**From:** Martyn White [REDACTED]  
**Sent:** 24 December 2019 10:03  
**To:** Planning.Responses [REDACTED]  
**Cc:** Finlay Gardner [REDACTED]  
**Subject:** AB/94/19/HH & AB/95/19/L

#### **AB/94/19/HH & AB/95/19/L**

No 30 High Street is a Grade 2 Listed Building and forms part of an imposing group comprising 30-34 High Street which terminate the sequence of street fronted historic commercial/retail buildings on the east side of High Street. The mid-18th Century facade of the group is of particular importance with its attractively bold brick detailing and fenestration

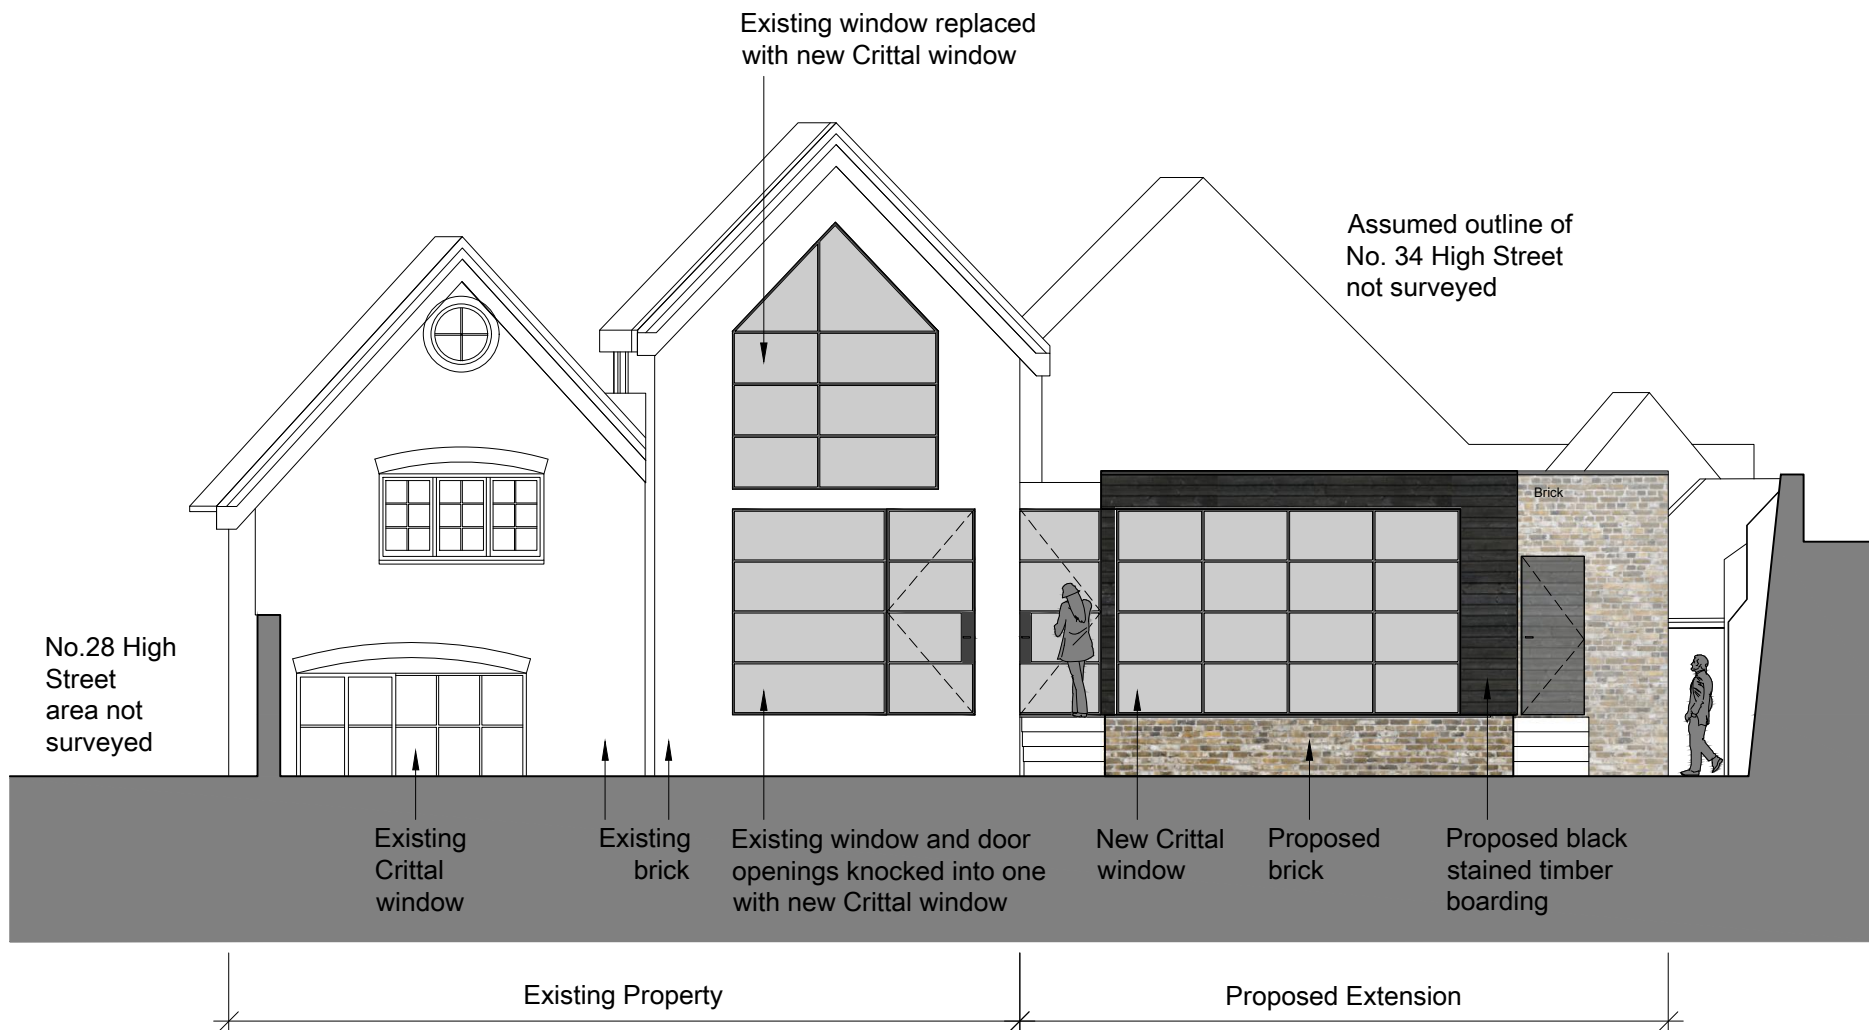
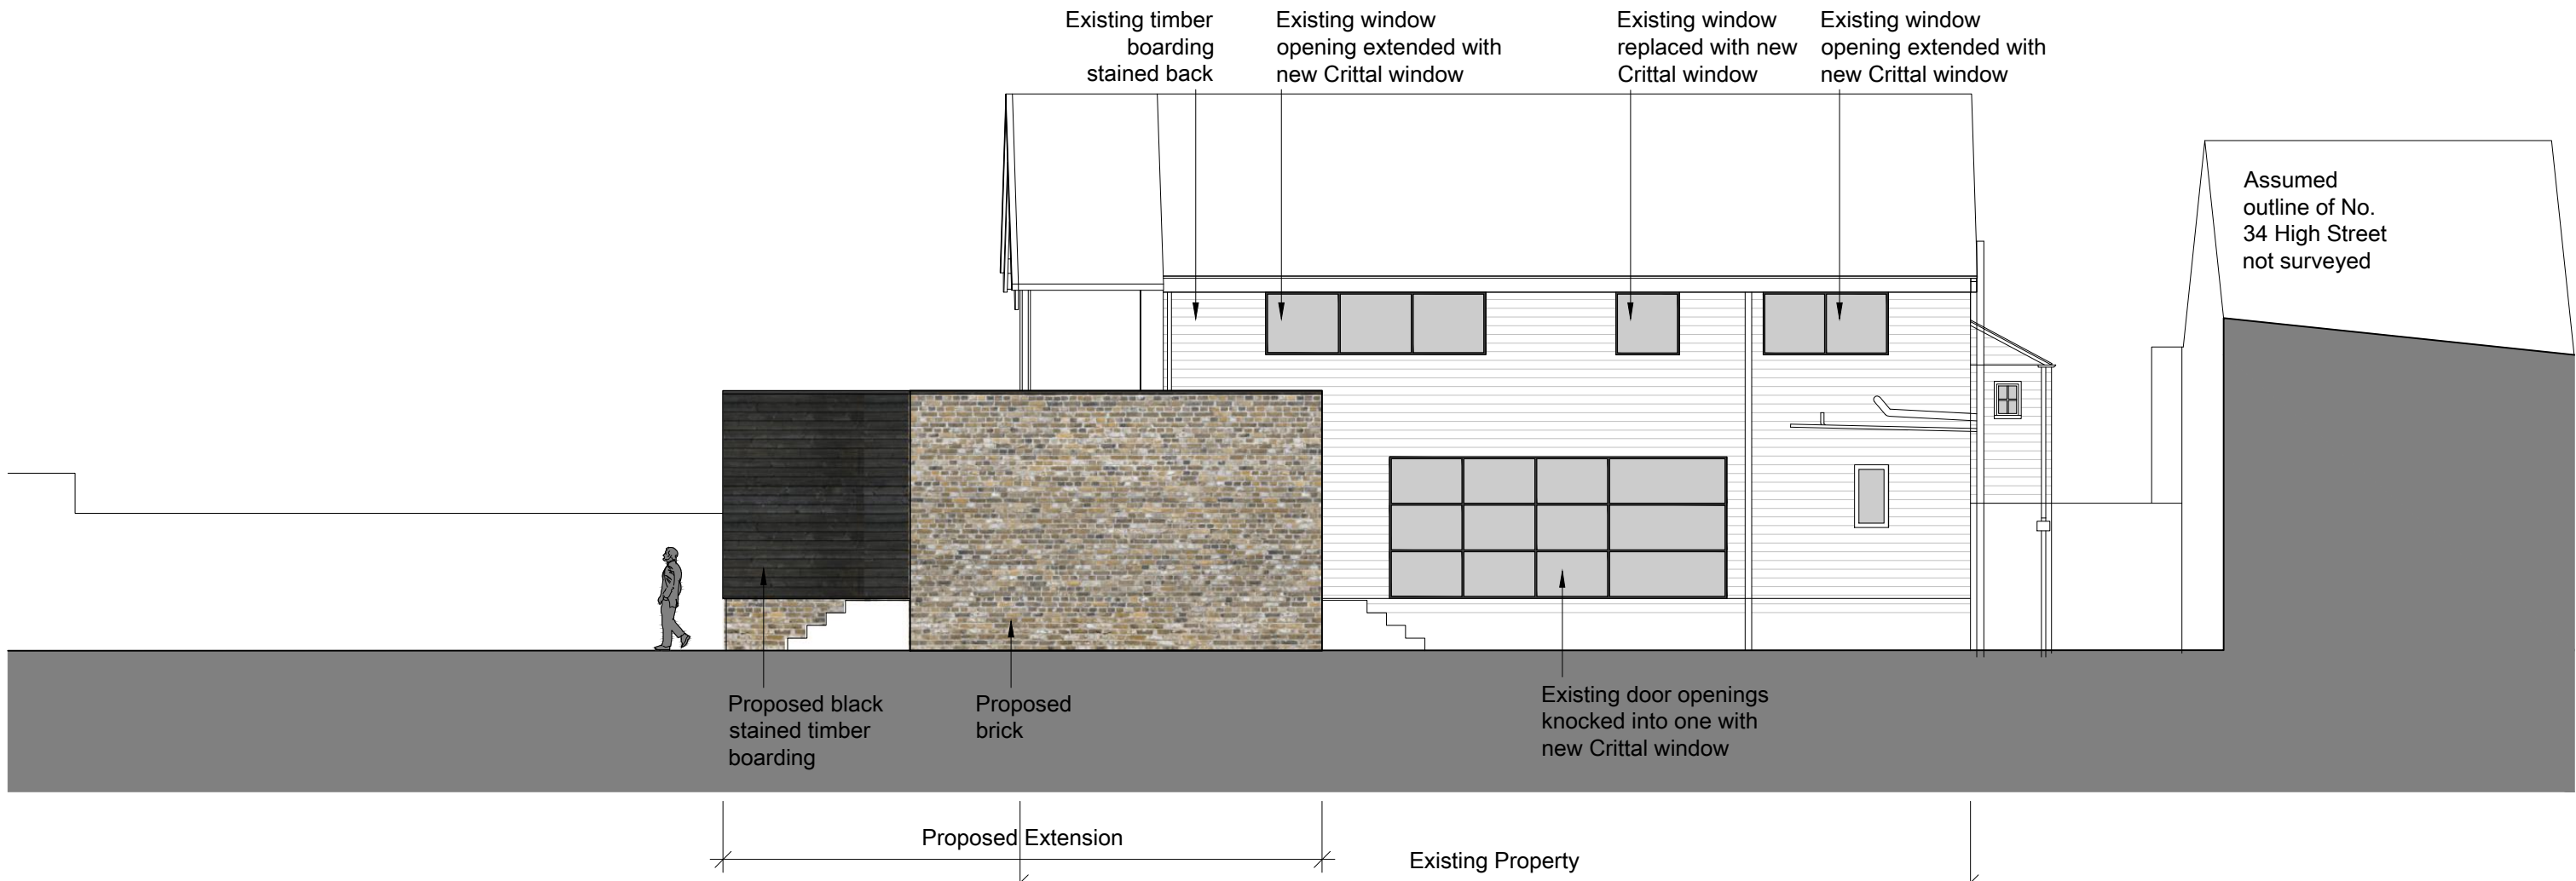
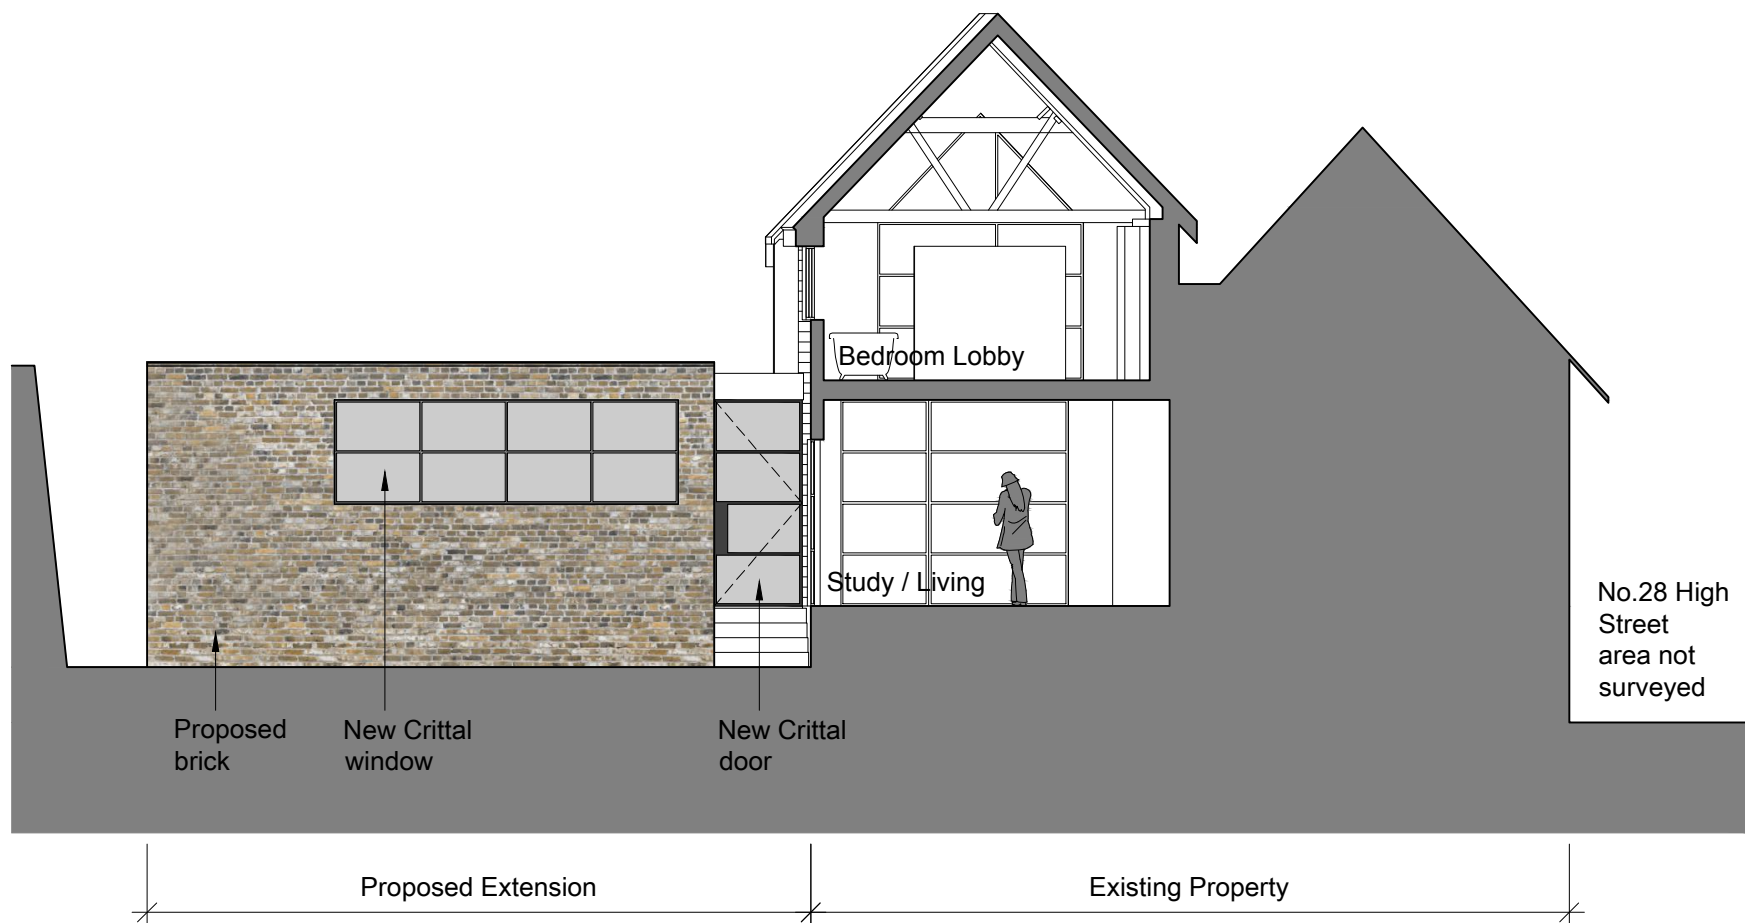
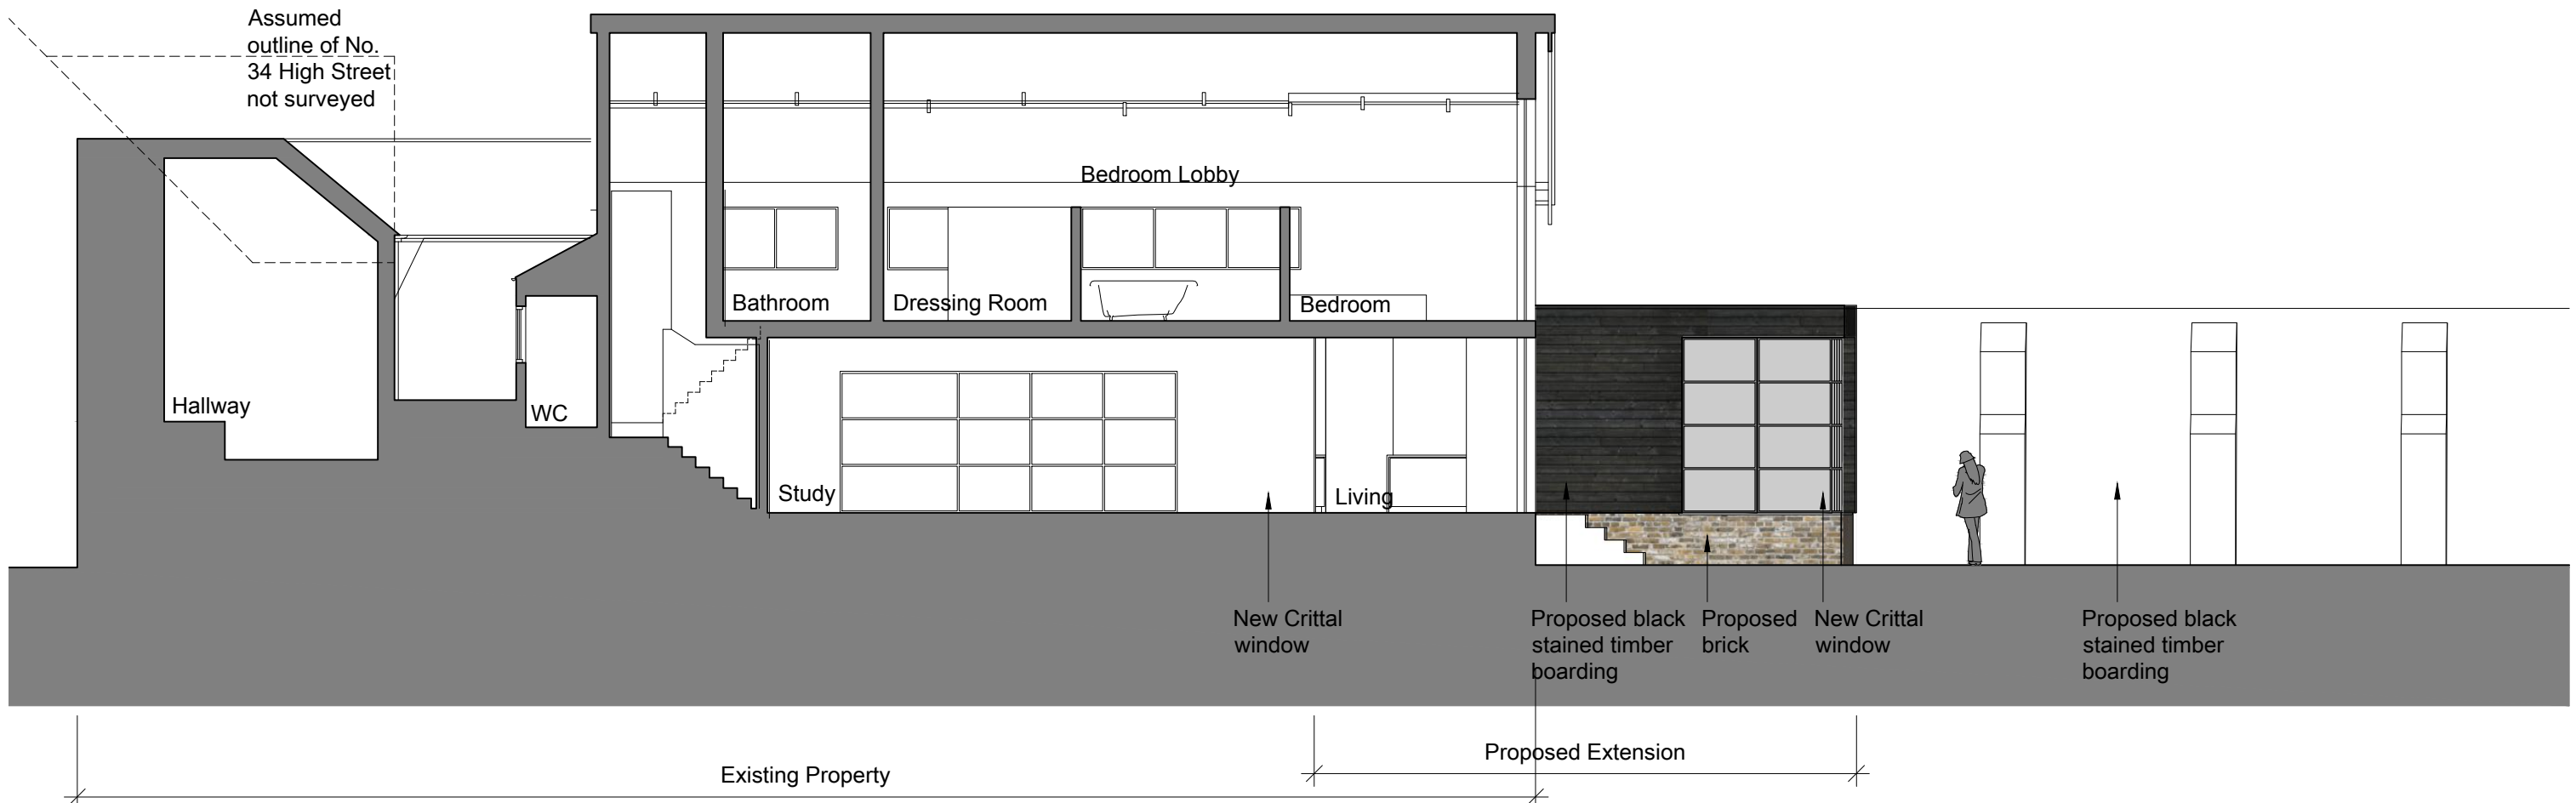
The proposed 'L' shaped extension is of a simple, modern design and a scale and height which does not impact adversely on the existing building. The proposed use of black cladding and a sedum roof enhance the simple characteristics of the host dwelling, and complement and add to the long historic building evolution of the premises. It is ultimately considered that this extension will complement the character and appearance of the host listed building.

The glazed link is of a design and scale that it will ensure that the building will read as a modern extension, whilst also allowing views through to the rear courtyard space.

It is also suggested that details should be submitted of the junction of the external walls with the roof of the proposed extension to ensure a finish and appearance appropriate to the modern design of the structure.
